# ENG-PUDSP22001-R2-PDR.pdf Markup Summary

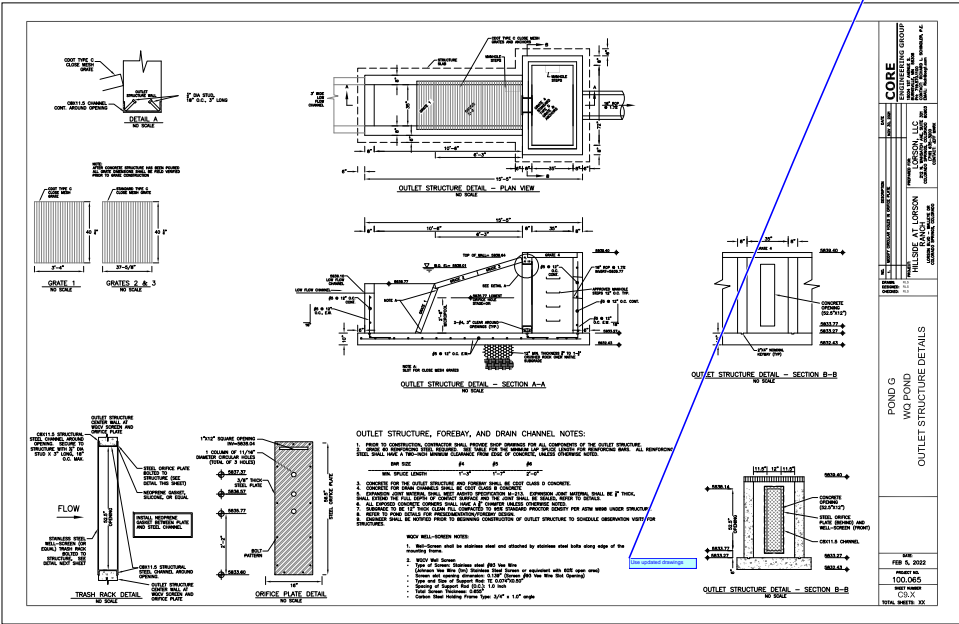
does not match what is shown on Sht C9.2 of GEC Plans. Revise to remove discrepancy.

Show maintenance access path to spreader
